The Sizewell C Project

**Natural England's Comments on Terrestrial Ecology Documents Submitted to
the Examination**

Planning Inspectorate Reference: EN010012

6th August 2021

DRAWING TITLE:  
MAIN DEVELOPMENT SITE  
KEY PLAN  
RULE 17 REQUEST FOR FURTHER  
INFORMATION

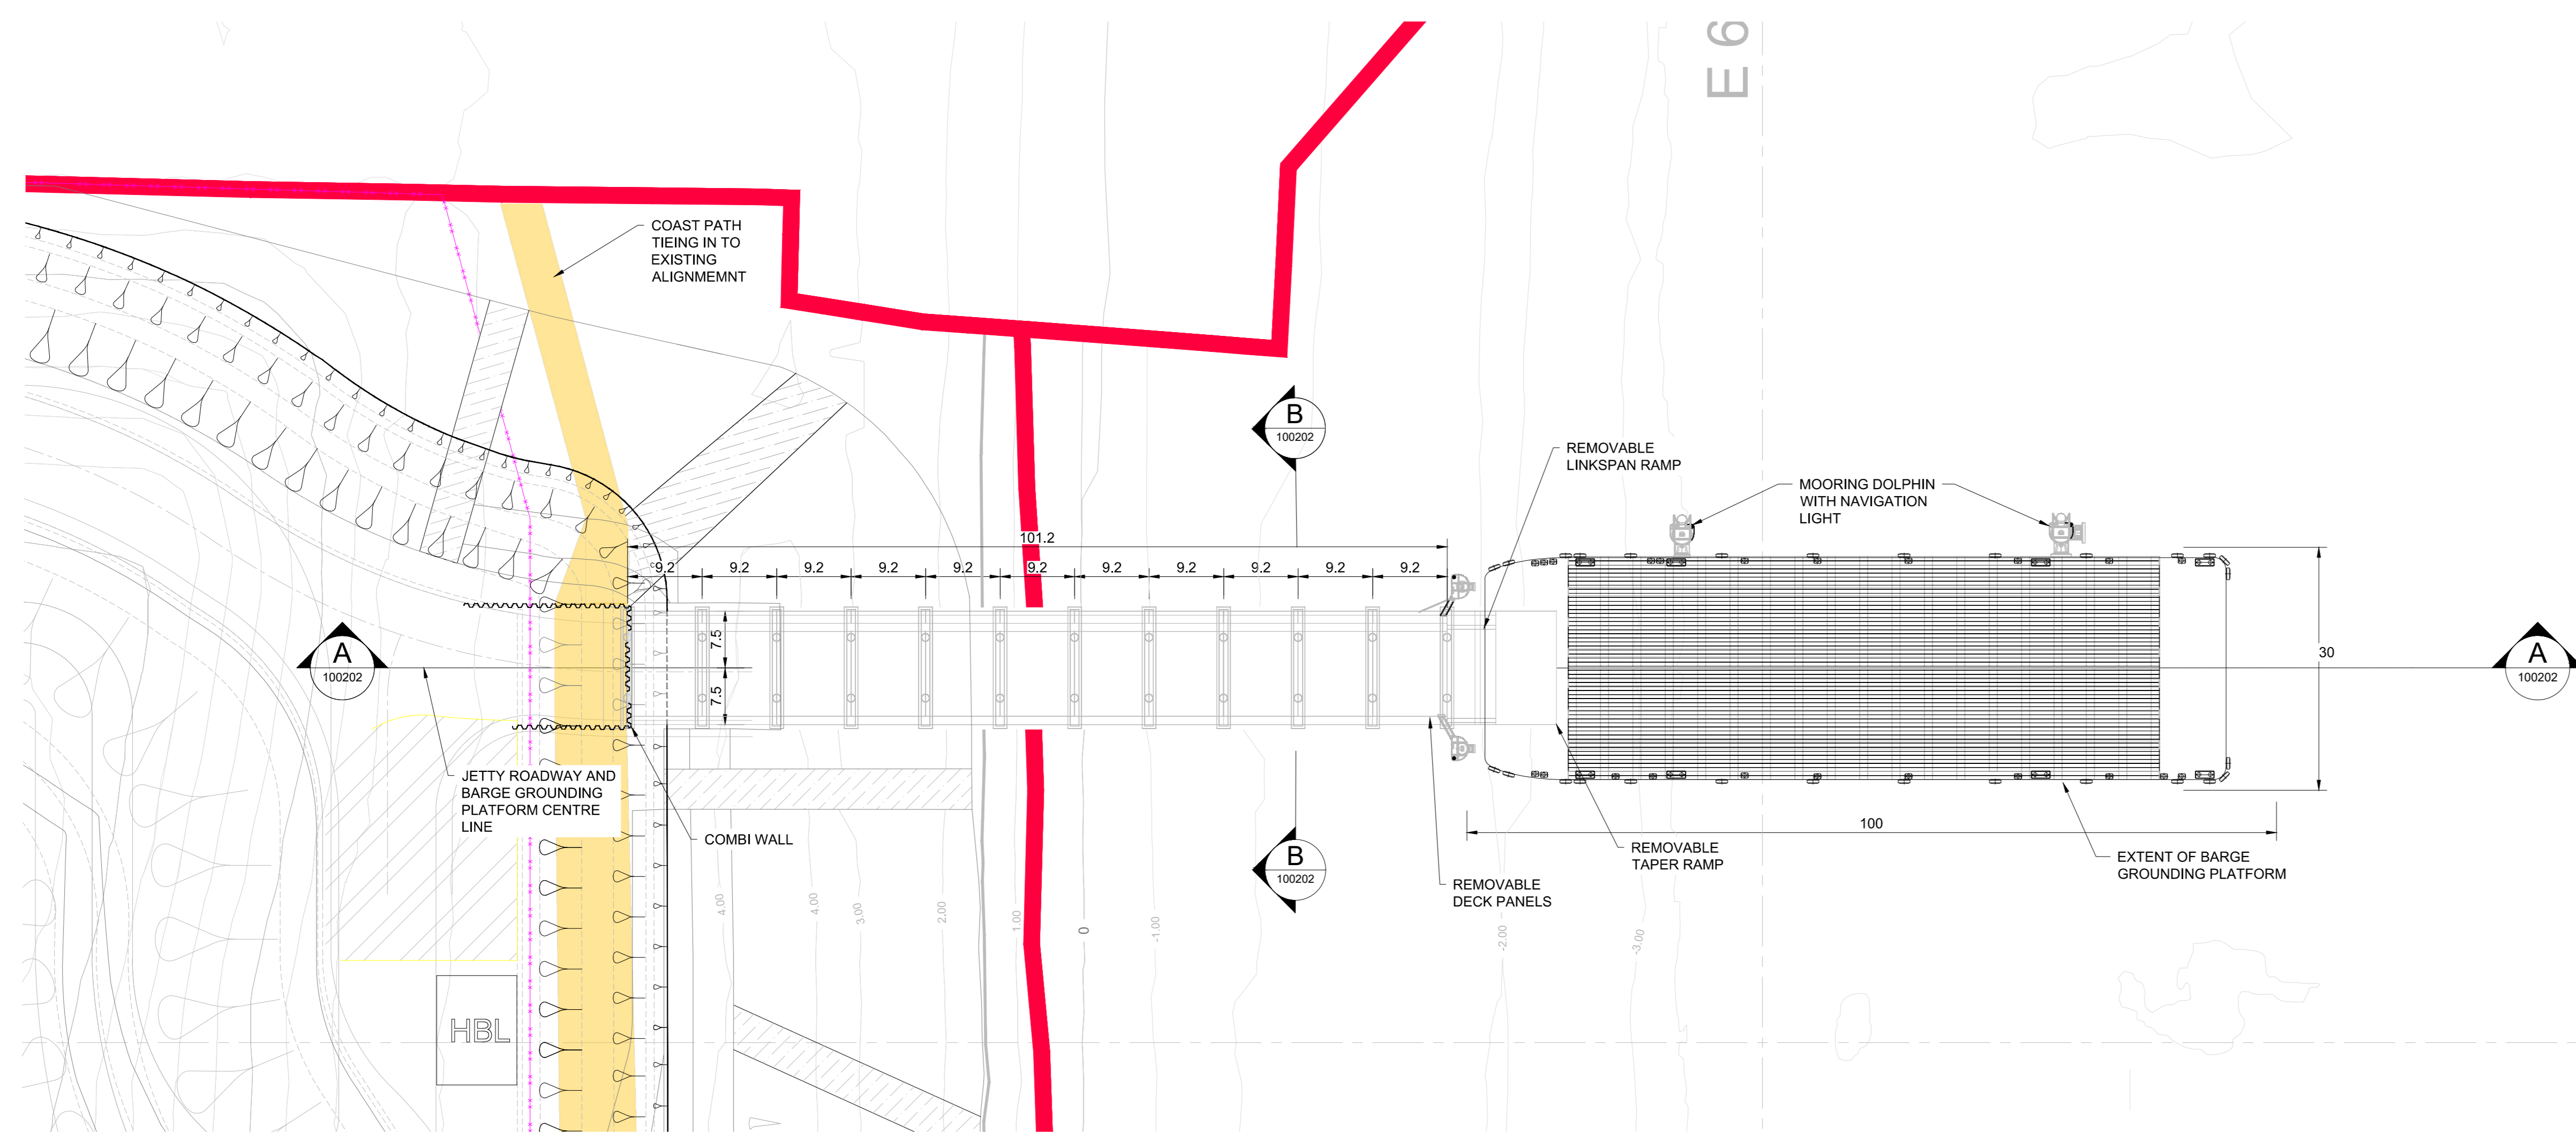
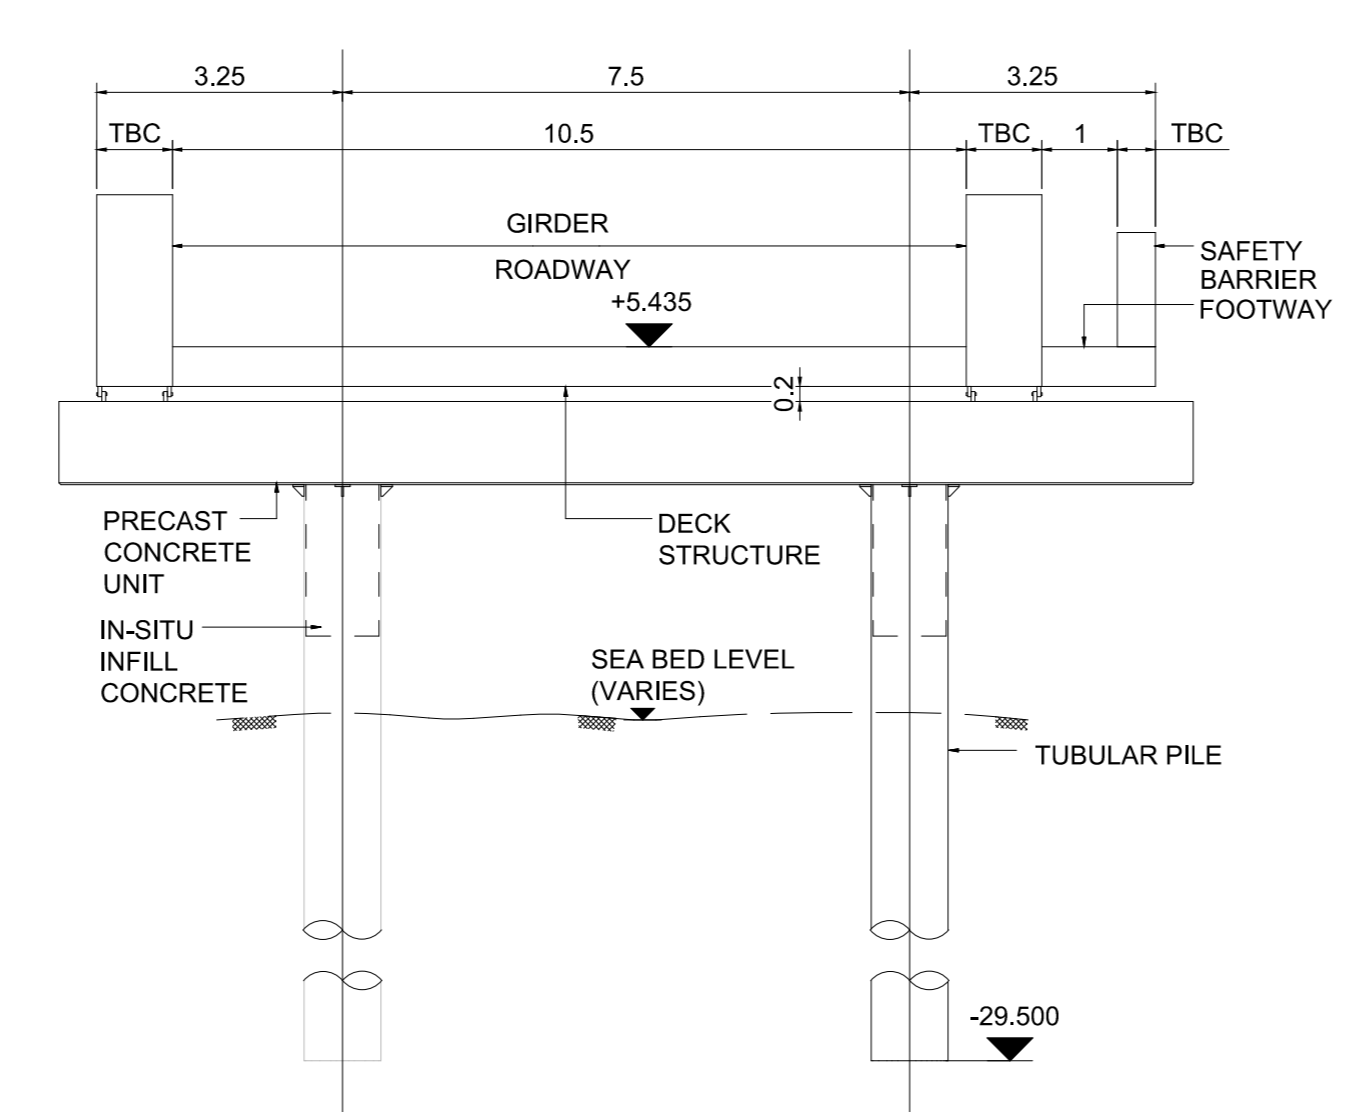
3.2 Natural England welcomes the submission of detailed designs for the first time during the examination. We are encouraged by the ongoing engagement on the SSSI crossing design and its optimisation for invertebrates and hydrology.

3.4 Currently Natural England is satisfied that our comments and those of the Environment Agency and other interested parties have been taken into account during the optimisation process of the SSSI hybrid bridge-culvert design option. We are currently reviewing these detailed plans with our specialist and hope to progress this issue further within upcoming iteration of our Statement of Common Ground.

**Plate 1: Location of new wetlands**

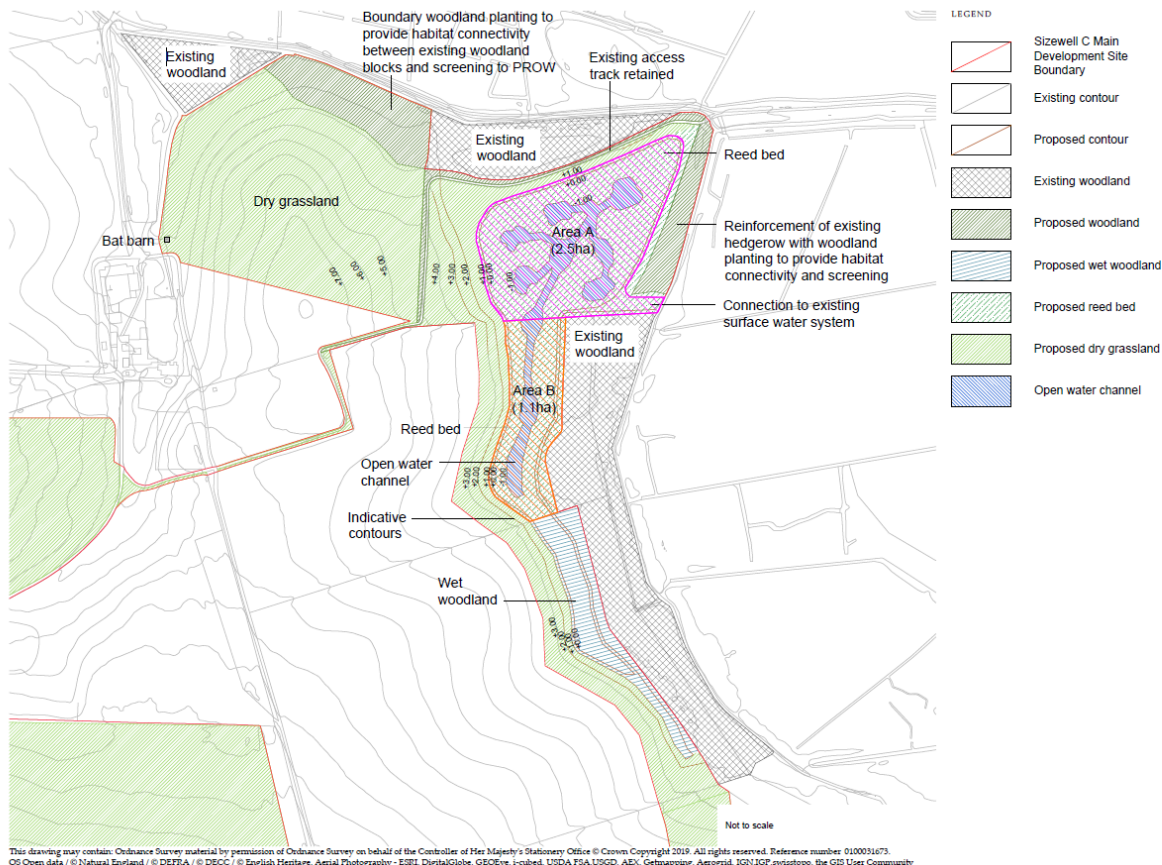
- i) The quantity of habitat provided from the outset is still less than that lost, with 0.7ha still proposed to be provided post construction which contradicts guidance that states habitats should be established before loss (DEFRA, 2012) not 10-12 years hence.
